3rd September 2021
Our Ref: DW/2031/DL7-030921

Application by NNB Generation Company (SZC) Limited for an Order Granting Development Consent for The Sizewell C Project (PINS ref: EN010012)

Deadline 7 submission by Dominic Woodfield (IP reference: 20025964)

The Sizewell C Project Headline Results Return to

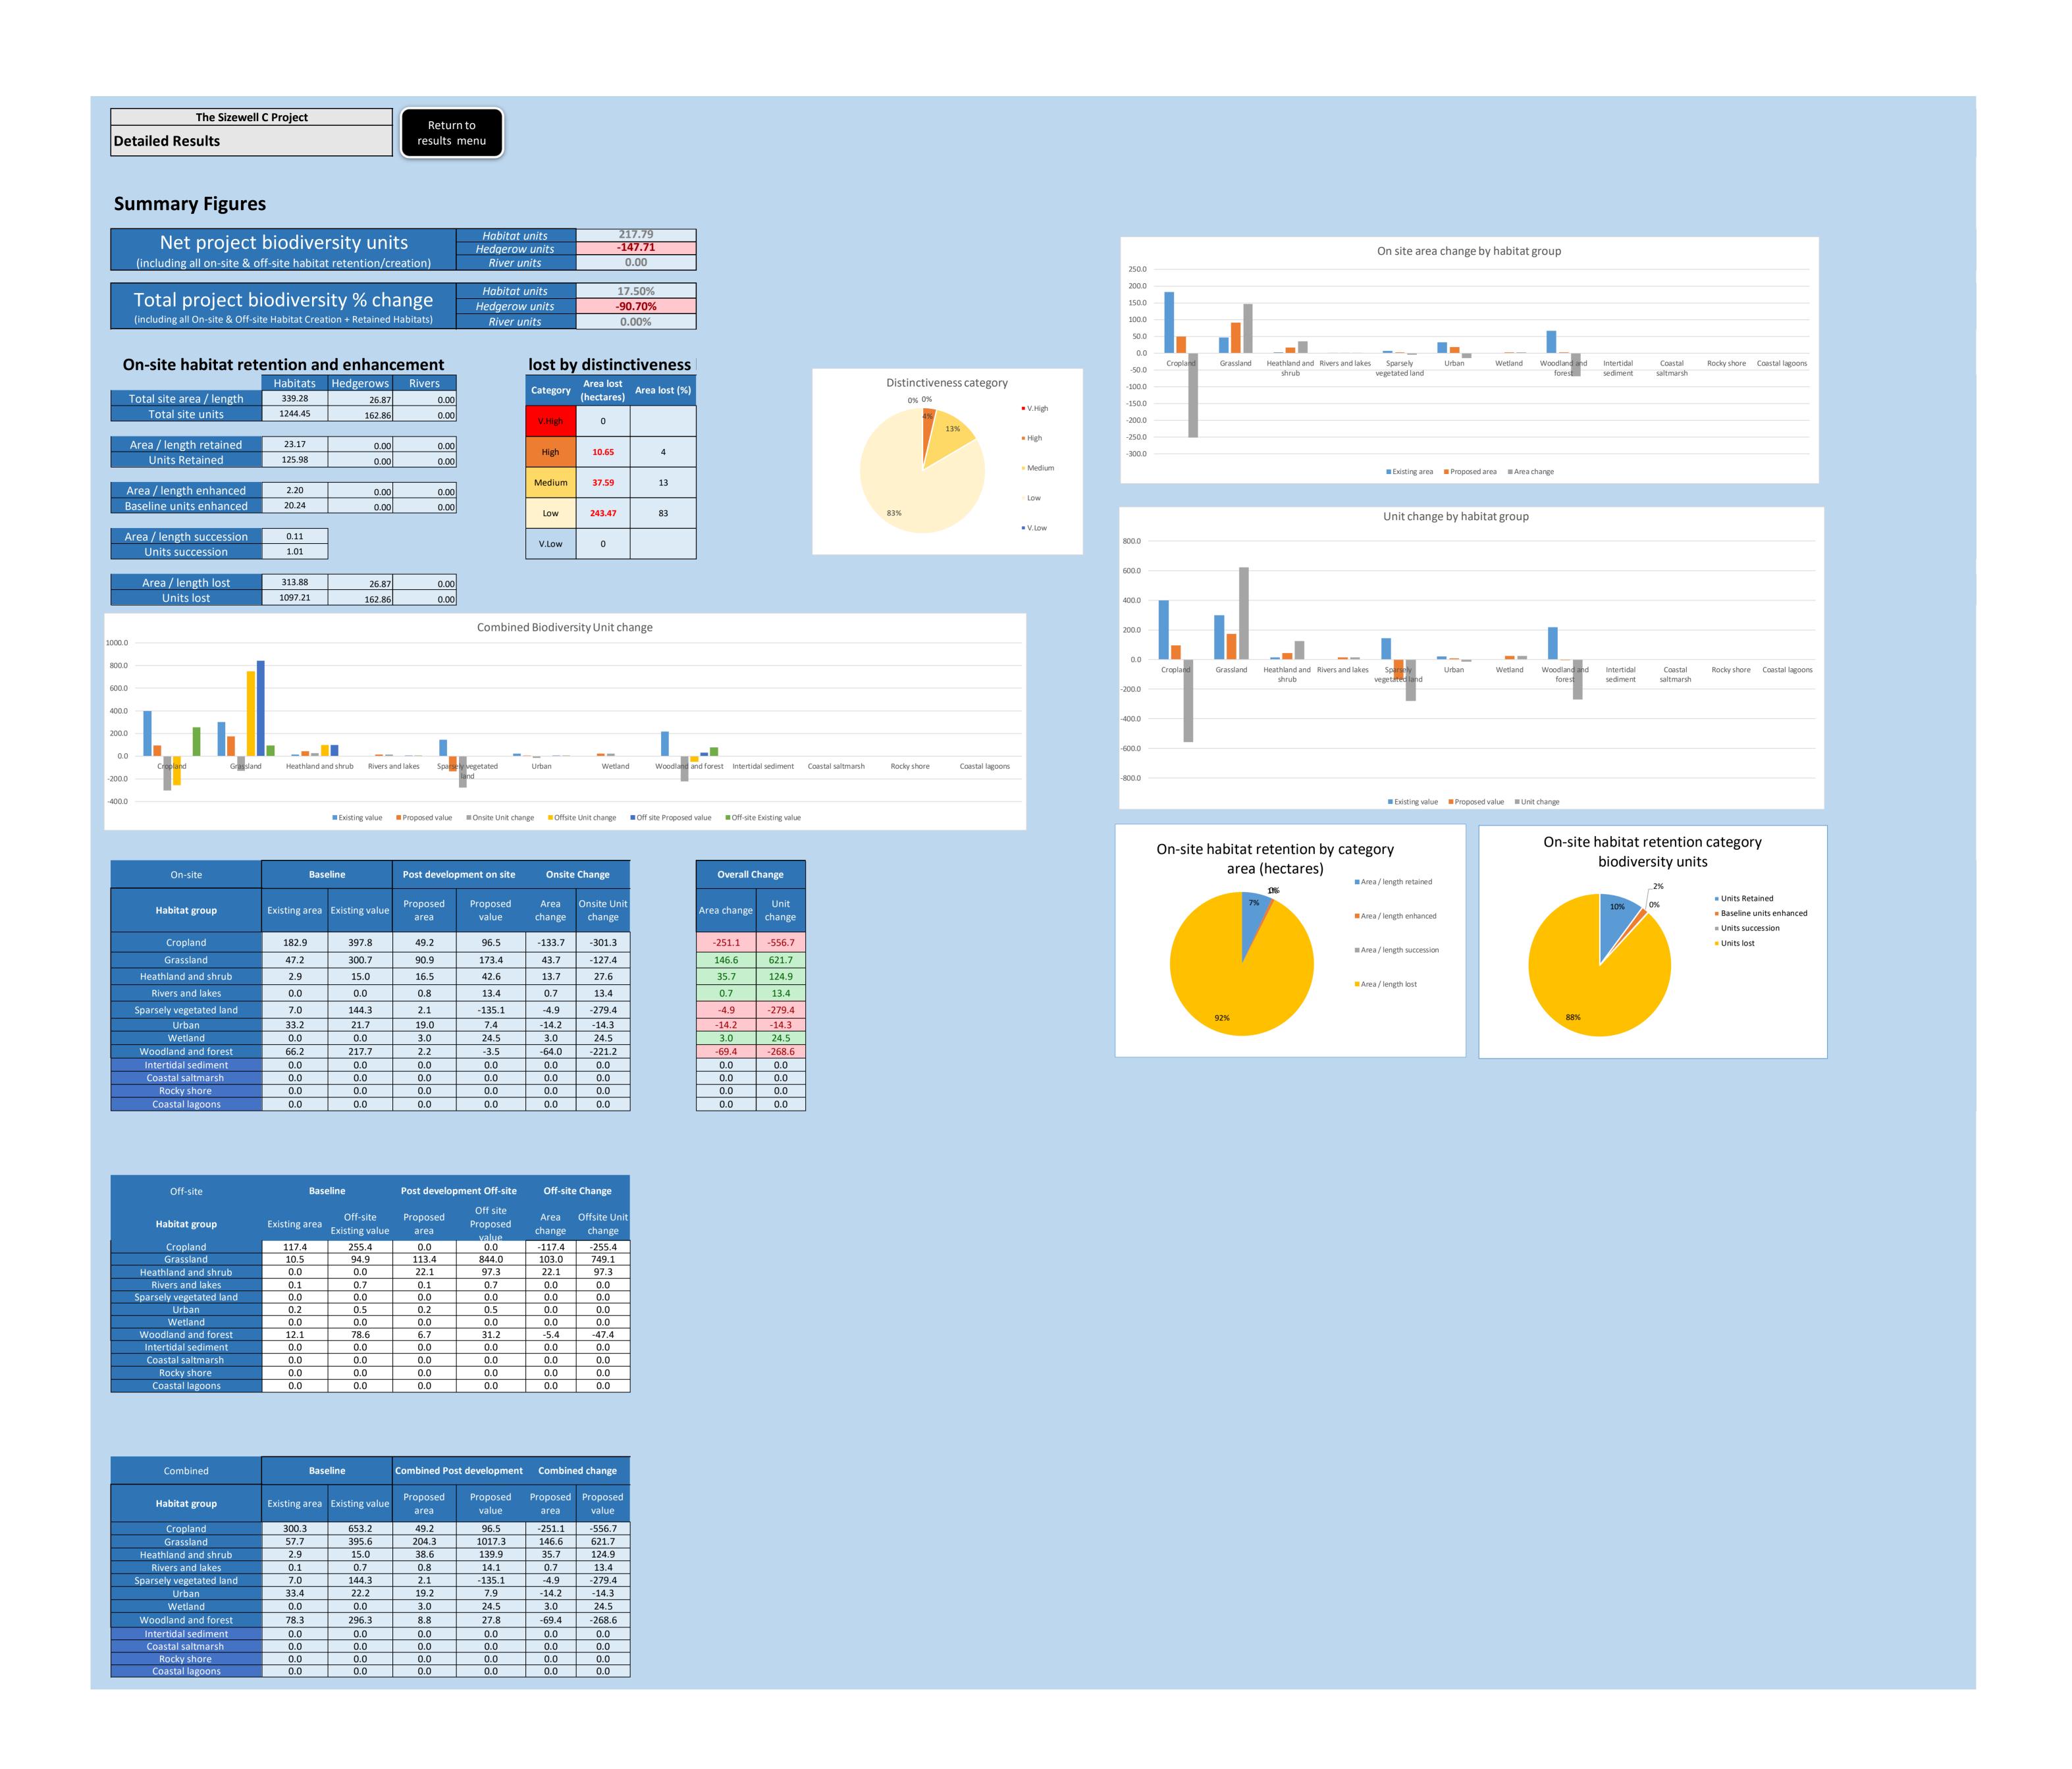
The attached Metric 2.0 calculation output, using the Applicant’s inputs, is 17.5% BNG (see ‘Headline Results’ tab). There are various reasons why, despite using apparently the same inputs, this headline figure may differ from the Applicant’s claimed 18.03% for the MDS, but the figure is close enough for illustrative purposes and the best that Bioscan were able to achieve with the information supplied by the Applicant (underlining why their spreadsheet is required for a proper understanding).

- 1) The suppressed condition of **all** habitats in the baseline state (tab A-1, column H). No baseline habitat across the entire area of the MDS (other than vegetated shingle) is currently assessed to be in better than 'moderate' condition. What this implies about the extant and past management of the Sizewell Estate is discussed at the foot of this letter. For now, the ExA is invited to experiment with adjusting the drop-down menu inputs for 'condition' in column H and observe the effect on the 'Total net % change' figure in the 'Headline Results' tab of even slightly more generous assessments of the condition of the various extant habitats. It will be seen how even a few modest adjustments cause the overall % change figure ('Headline Results' tab) to dwindle rapidly towards nothing and then move into the negative.

- 2) The contrasting and liberal use of 'good' and 'fairly good' condition that is applied by the Applicants to future habitats in the Habitat Creation tab A-2. Again, the ExA is invited to experiment with slight adjustments to the

drop-down menu inputs from column G of this sheet, observing the effect on the overall % change output figure of slightly more conservative predictions of what is likely to be achieved in the future (perhaps having in mind the debate over the degree of success of heathland and acid grassland at Aldhurst Farm for which I note FOE (SC) are submitting further information at Deadline 7). Once again it can be seen how the net gain figure dwindles rapidly towards nothing and then into the negative with such apparently minor adjustments.

If the ExA considers the effect of both of the above exercises cumulatively (adjustments to both tab A-1 to reflect higher baseline scores and adjustments to tab A-2 to reflect more realistic future habitat condition scores) the effect will be seen to be compounded. This is before one comes on to consider concerns about the time lag before some compensatory habitats even begin to be created, concerns that have been articulated by Mr Paul Collins. By reference to column O in tab A-2 (Habitat Creation), even if one agrees with all of the 'default' timescales listed in these cells, for some of these habitats the starting point will be many years after loss, meaning an exaggerated level of biodiversity deficit in the short to mid-term.

In short, it would only take very few corrections of 'condition' assessment errors to wipe out the Applicant's claimed net gain figure. And the justification for such corrections is clear: take 'other coniferous woodland' (Tab A-1 row 27) for example. This appears to relate to the County Wildlife Site at Goose Hill, an open-structured plantation woodland with broad species-rich rides important for a range of scarce species. While a 'poor' condition categorisation might apply to a dense Sitka spruce plantation with a carpet of needles on otherwise bare ground under densely spaced-trees that blot out the light, is it right to apply such a categorisation to Goose Hill? Is this c.45.5ha site really all in 'poor' condition? If one disagrees that it is, and adjusts the condition up to merely 'moderate' (itself a conservative assessment²), this single intervention (or correction) drops the headline output result immediately by over 7 percentage points to just over 10% - i.e. almost cutting the claimed net gain figure in half. Any further such corrections to the baseline will further denude the output figure towards 0% and into net loss.
